PL- Consultation- Conservation Officer response

LU/25/26/PL

Address: 6A & 7A Selborne Road and 25B & 25C Western Road Littlehampton BN17 5NN

Proposal: Change of use from light industrial with 1 No flat to 7 No flats, first floor extension and solar pv panels on the flat roof.

Ground floor as proposed

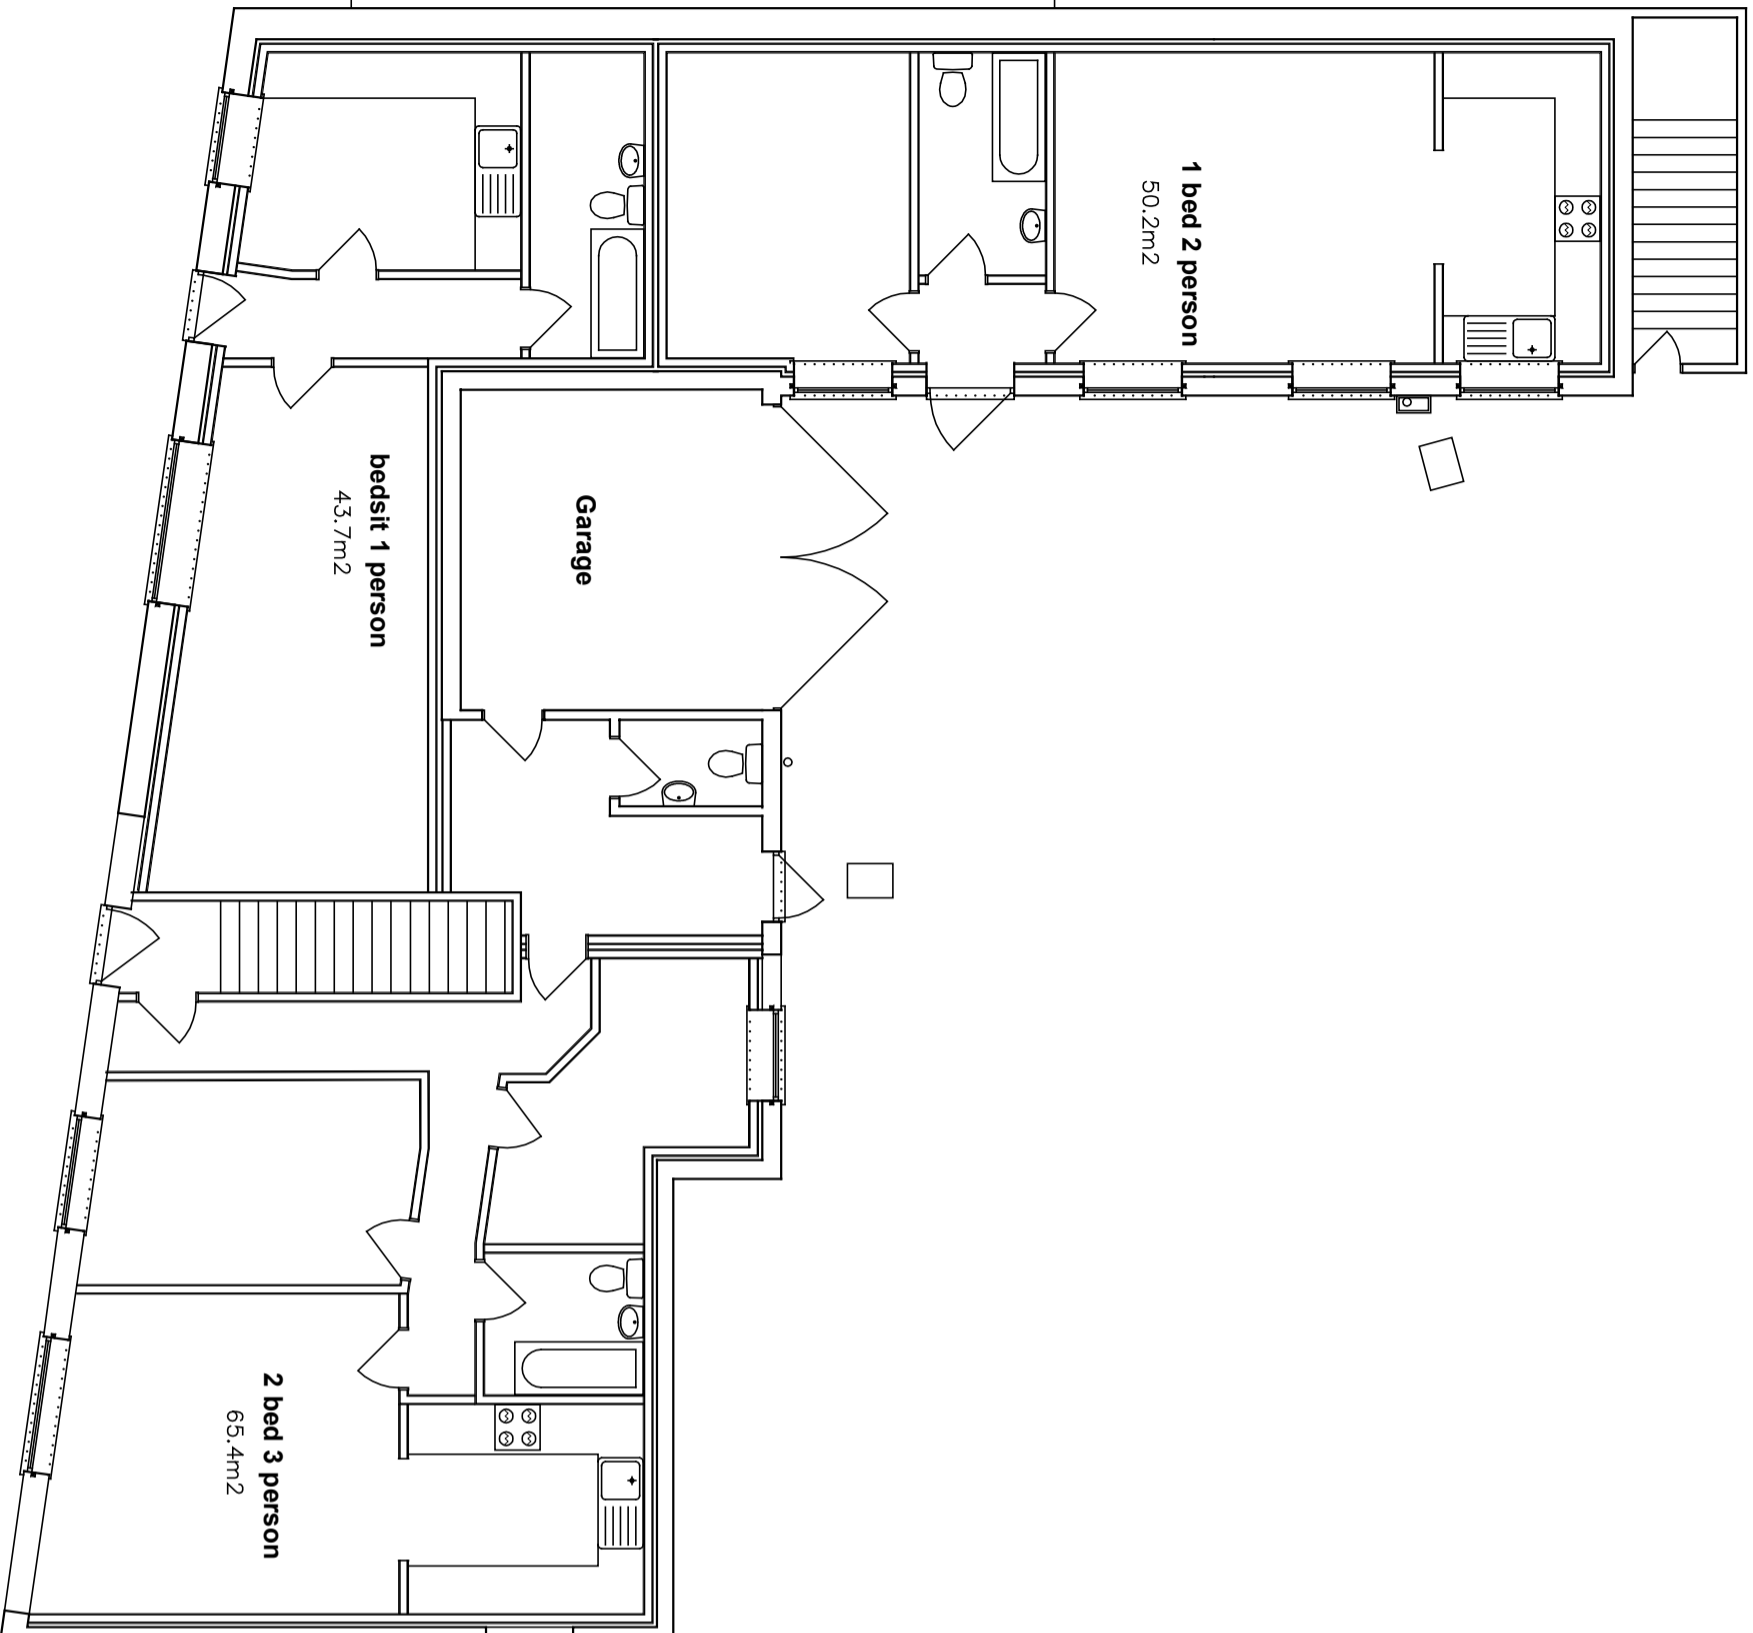
The use of uPVC within the conservation area is also a concern, as is the overall quality of detailing, including the design of both windows and doors. The retention of a garage is further questioned, as this space could potentially be more effectively utilised as habitable accommodation if appropriately designed.

There are also issues with the internal layout of the building, although these are not necessarily heritage matters. Ideally, historic divisions and walls would be retained and used to help inform the new layout. This could include a more open-plan arrangement that retains character while providing modern living spaces.

Elevations as proposed

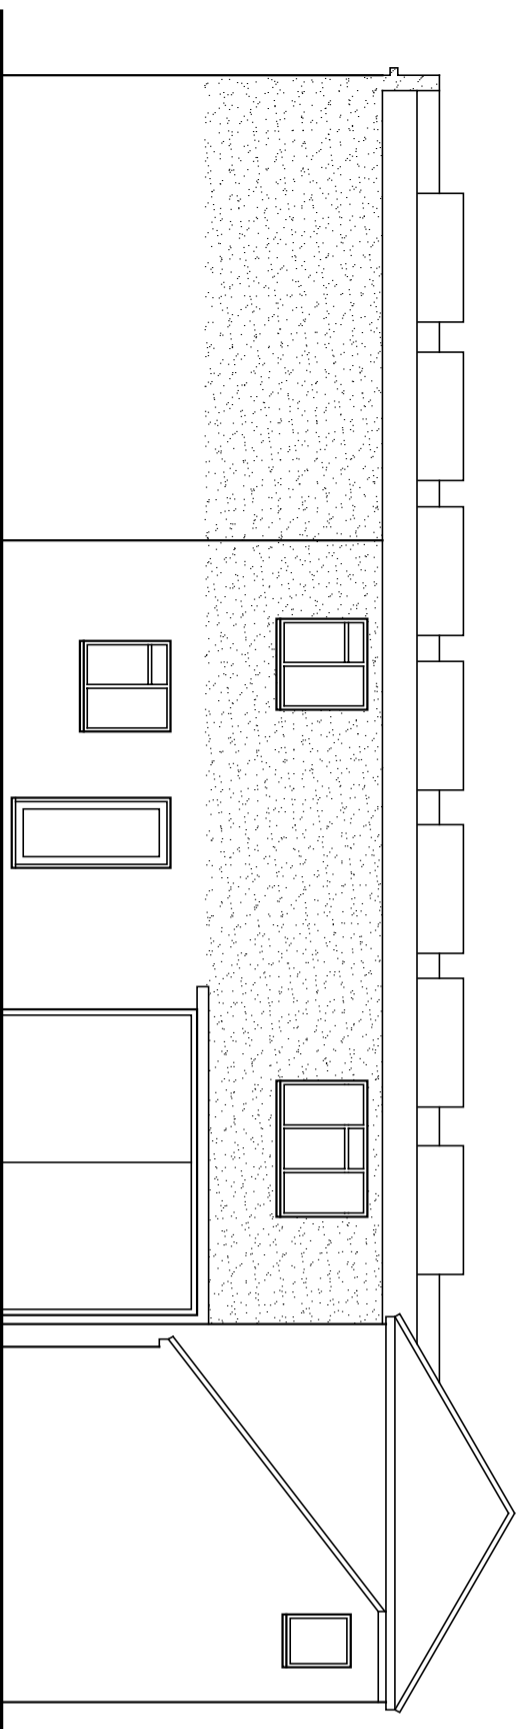
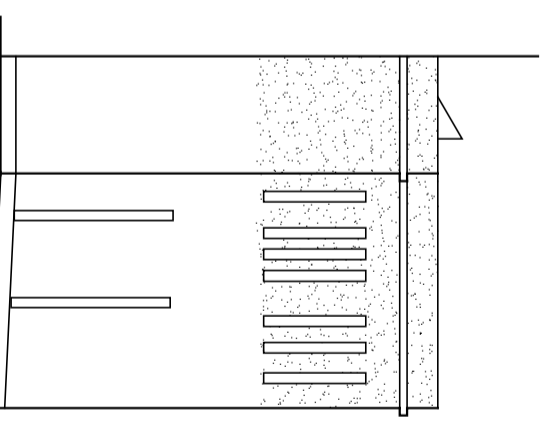
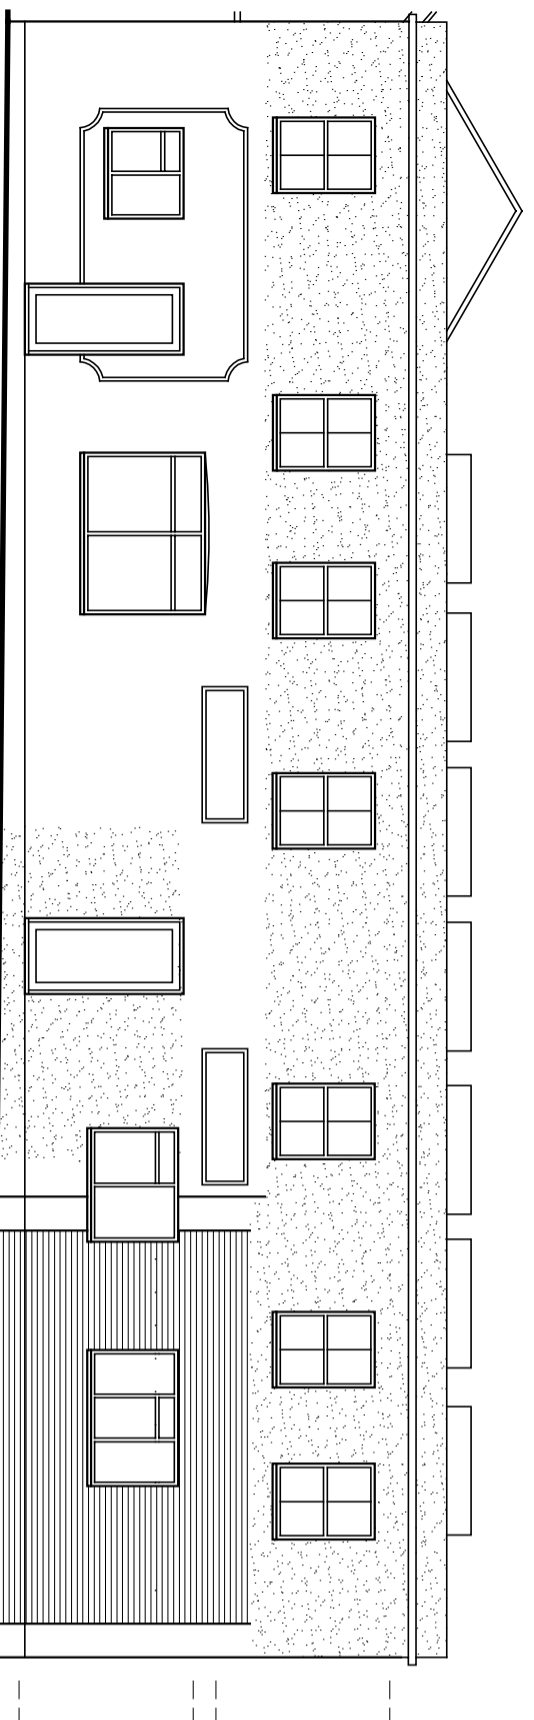
Unlike the existing building, which is clearly broken down into smaller elements, the upward extension reads as a single, large mass which runs continuously across much of the building. It does not reflect the stepped, piecemeal form of the existing building.

The proposed fenestration pattern is inappropriate. The large historic openings, which are essential to the appearance and character of the building on the northern elevation would be infilled and replaced with smaller, domestic-scale windows that are out of keeping with the original form and function of the building. The existing large doors should be adapted so that they allow light into the building, while retaining these openings as positive contributing features. This is a known approach in traditional buildings such as this one.

Further, the first-floor windows introduced as part of the upward extension do not reflect the industrial character of this elevation. Their regular spacing and domestic proportions give the building a residential appearance, rather than responding to the more functional and robust character of the original structure. Their use in this part of the building is therefore considered inappropriate and not characteristic of the building's historic industrial form or function.

Furthermore, the southern elevation of the upward extension introduces standard modern casement windows which are overtly domestic in appearance and lack the depth, proportion and robustness associated with industrial or commercial buildings. These too are out of character.

**Street view and roof plans**

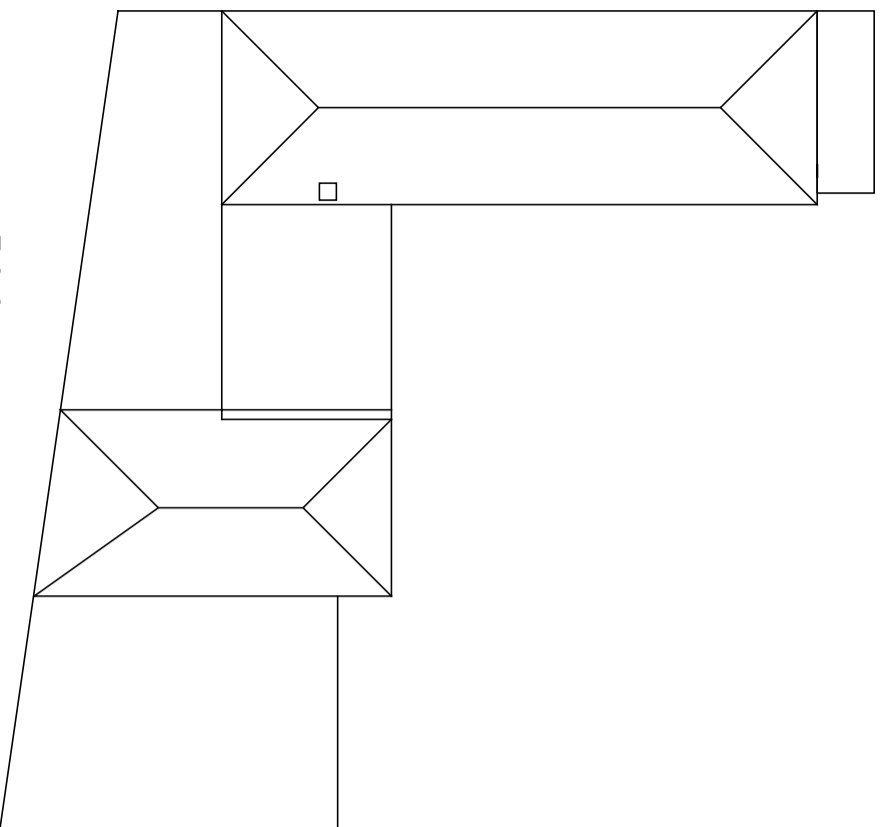
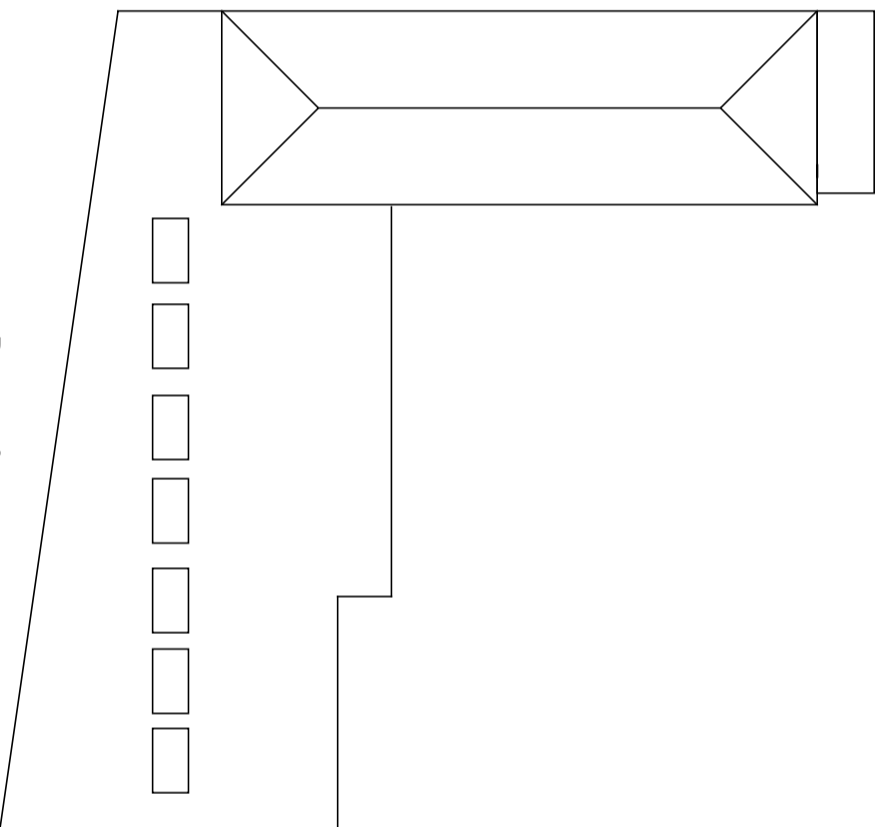
Although the inclusion of solar panels is acknowledged as a positive feature, they do not appear to be a positive feature as designed. This approach followed needs revision.
